**MASTER DEVELOPMENT DRAINAGE PLAN FOR
AUTUMN HILLS (NE4 SEC 36-12-65) SKETCH PLAN
EL PASO COUNTY, COLORADO**

AUGUST 2022

MERIDIAN HILLS LLC

TERRA NOVA ENGINEERING, INC.

1. THE MAIN ENTRANCE AT THE STAPLETON DRIVE AND LIBERTY GROVE DRIVE INTERSECTION WILL BE PART OF PHASE 1.
2. THE SANITARY SEWER LIFT STATION AND CONNECTION TO THE PUBLIC SYSTEM WILL BE PART OF PHASE 1.
3. DRAINAGE PATHS TO THE STORMWATER PONDS WILL BE PART OF PHASE 1.

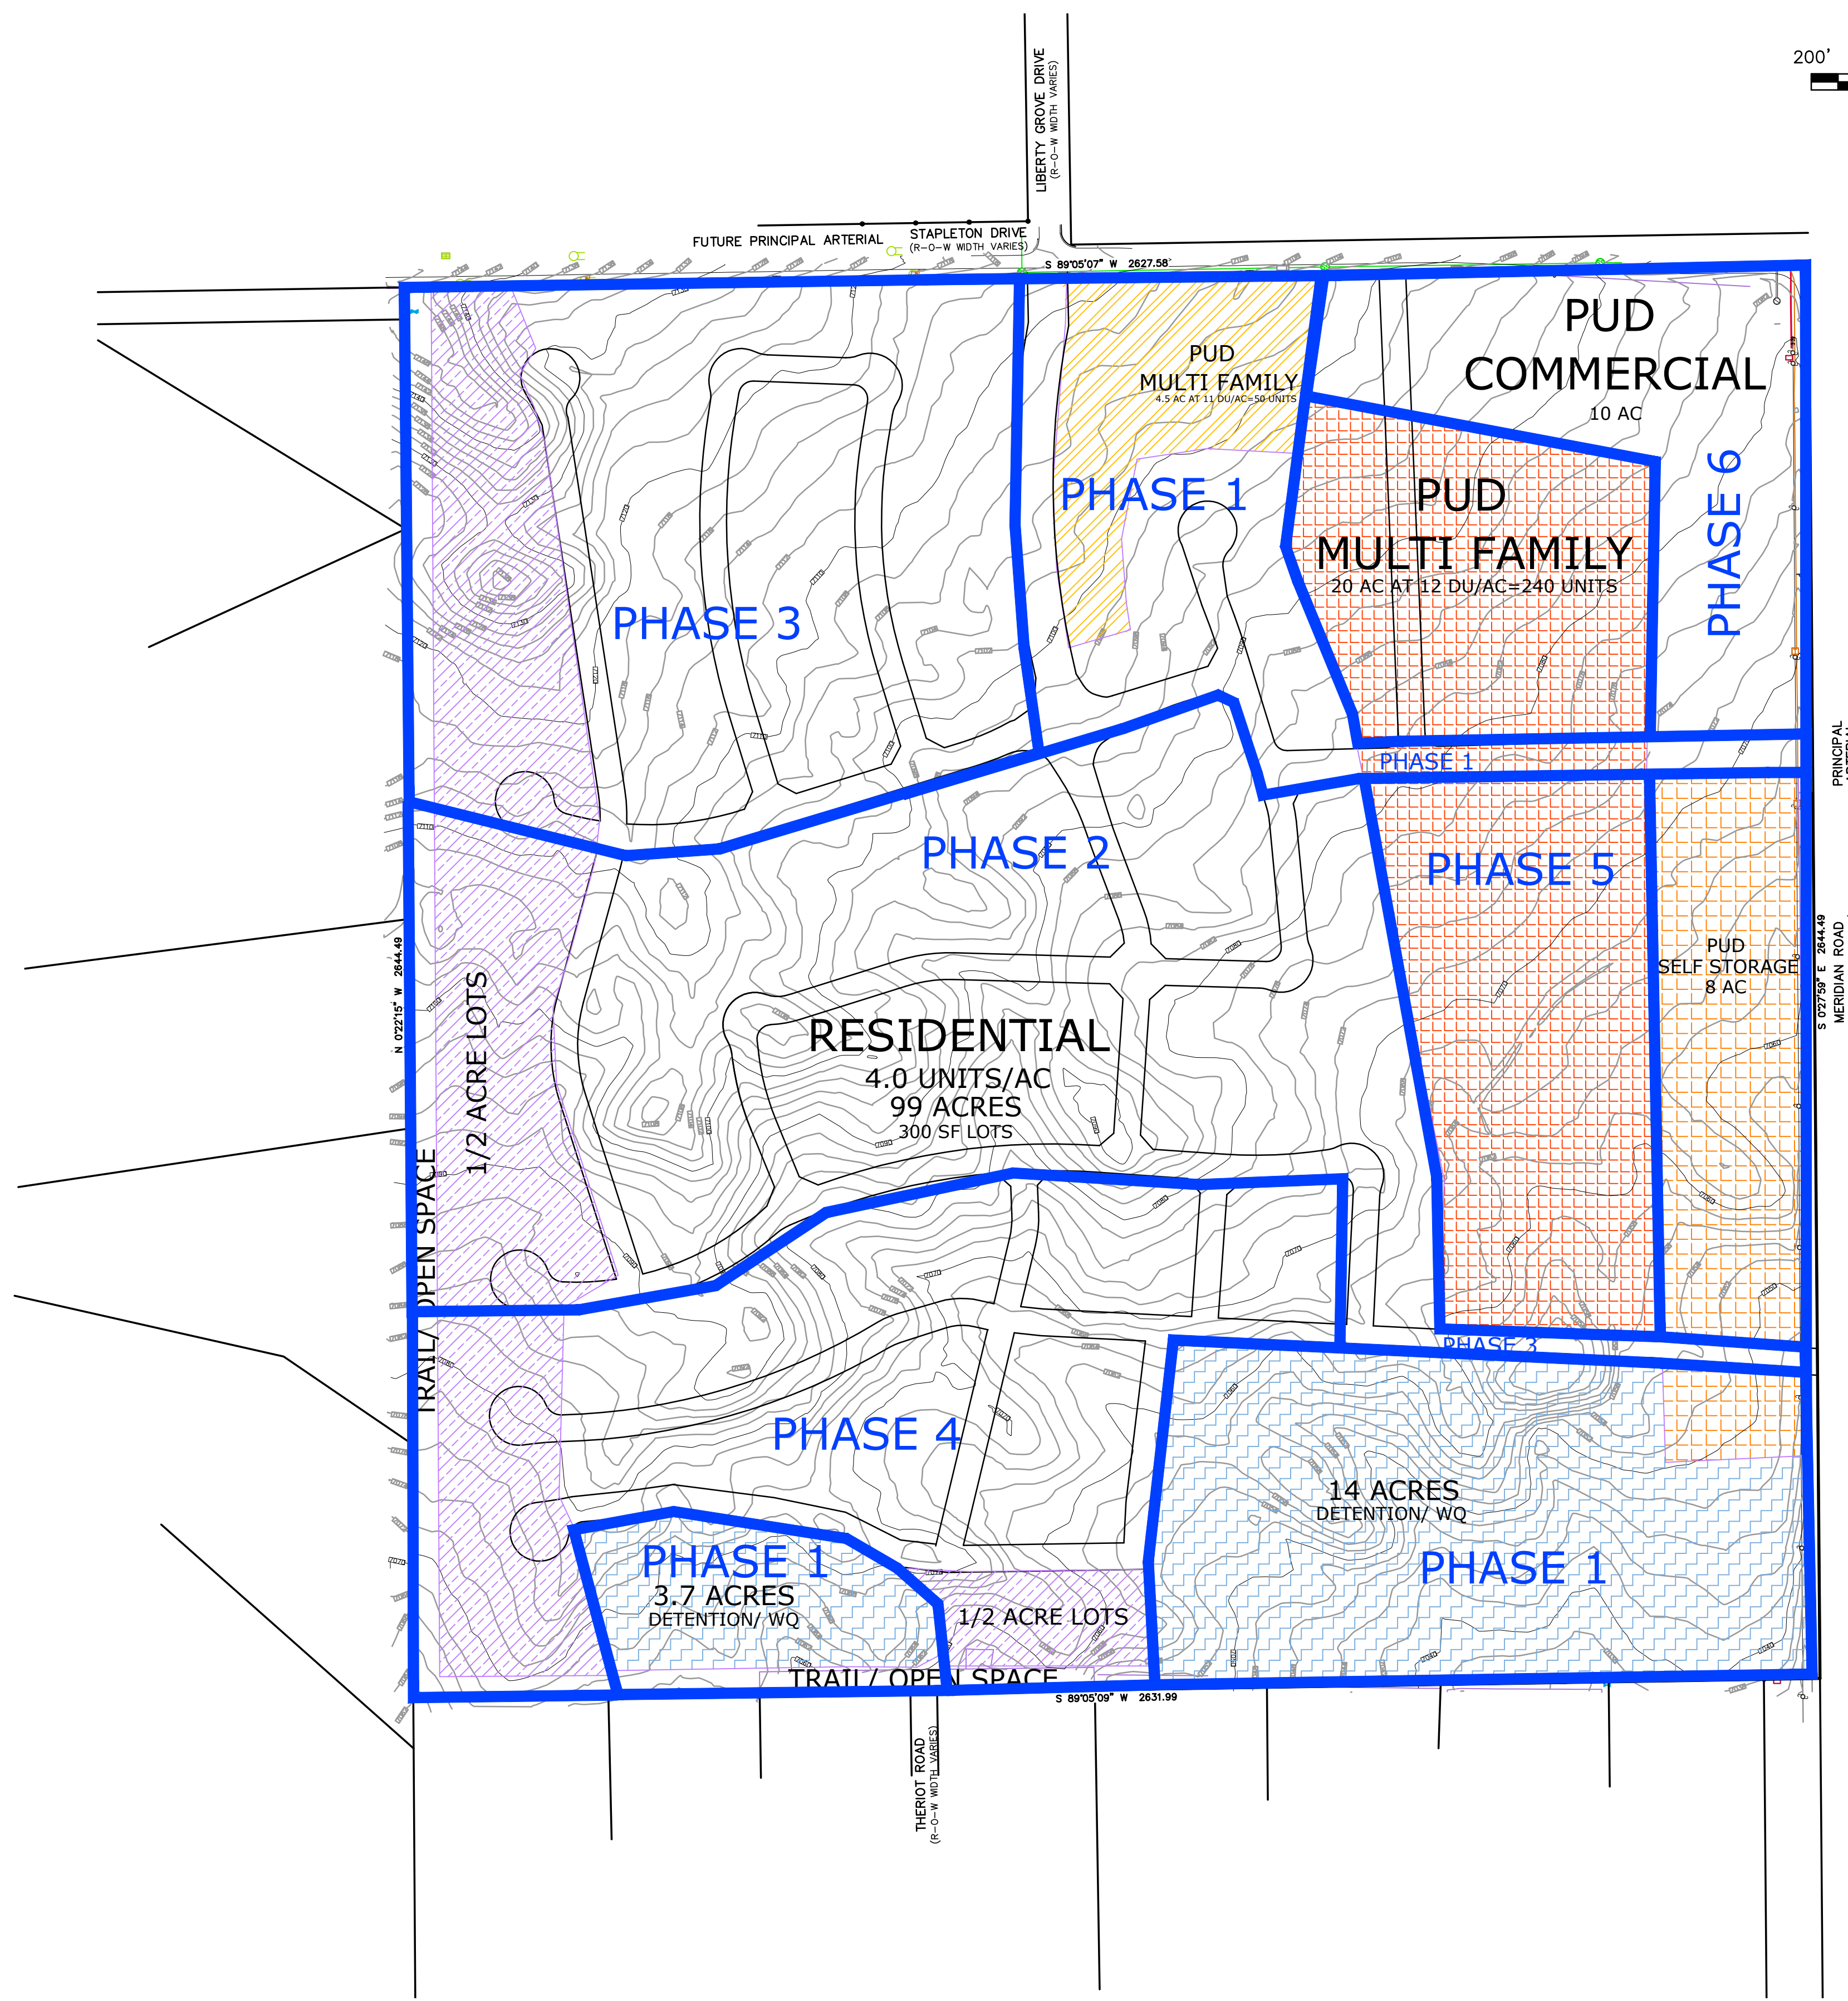
identify who will own/maintain the two detention ponds.
Discuss the phasing plan of the two detention ponds. The submitted phasing plan shows both ponds are part of Phase 1. however, phase 1 improvements only drains toward the eastern pond. Why is the western pond included with Phase 1.

REVISIONS	NO.	DESCRIPTION	DATE

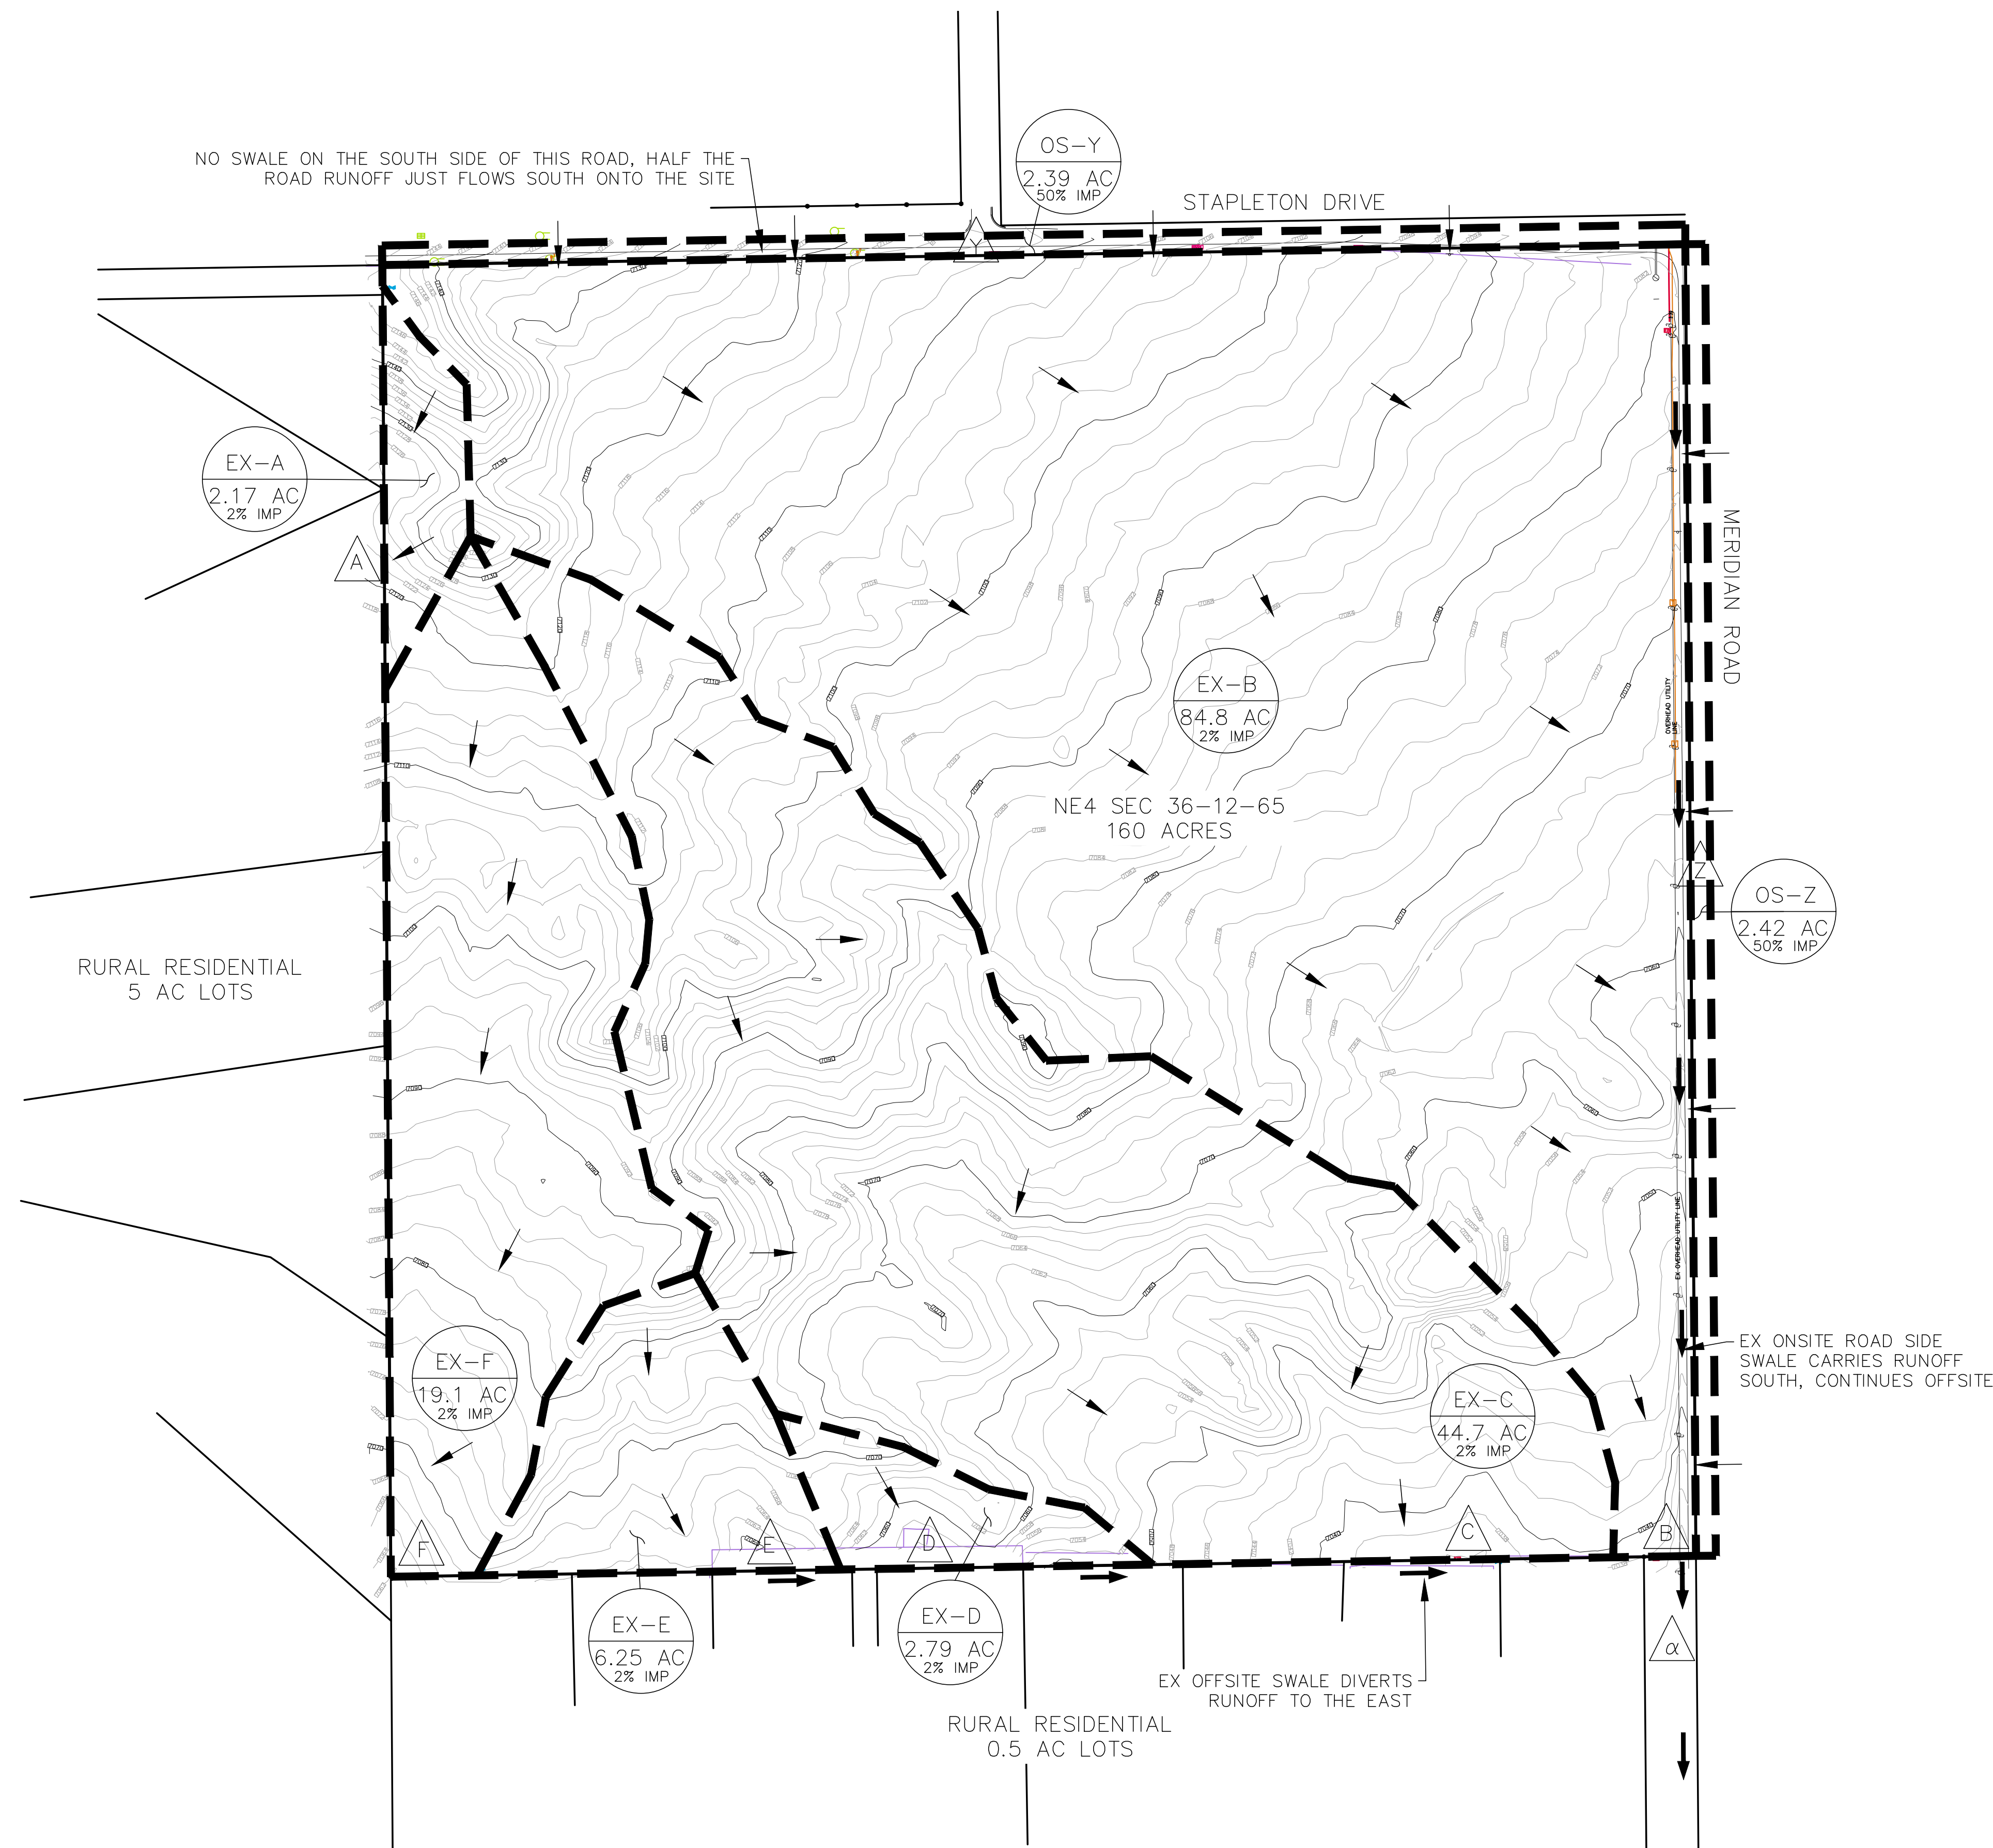
Please clarify as the drainage map does not depict the Bennett Ranch drainageway along the east side of the site. Additionally it is stated above and below that there is just a roadside swale along Meridian road which is on the east side of the site

identify were the other 20% leaves the site

Adjust the Offsite Basin boundary for Meridian Road to include the full road section per the Meridian (North) Access Control Plan. The Control Plan shows runoff from the eastern half of Meridian will be collected by inlets and routed into the ditch on the west side.

Basin and roadside ditch assumption needs to account for the ultimate condition of Meridian Road. Narrative should state as such.
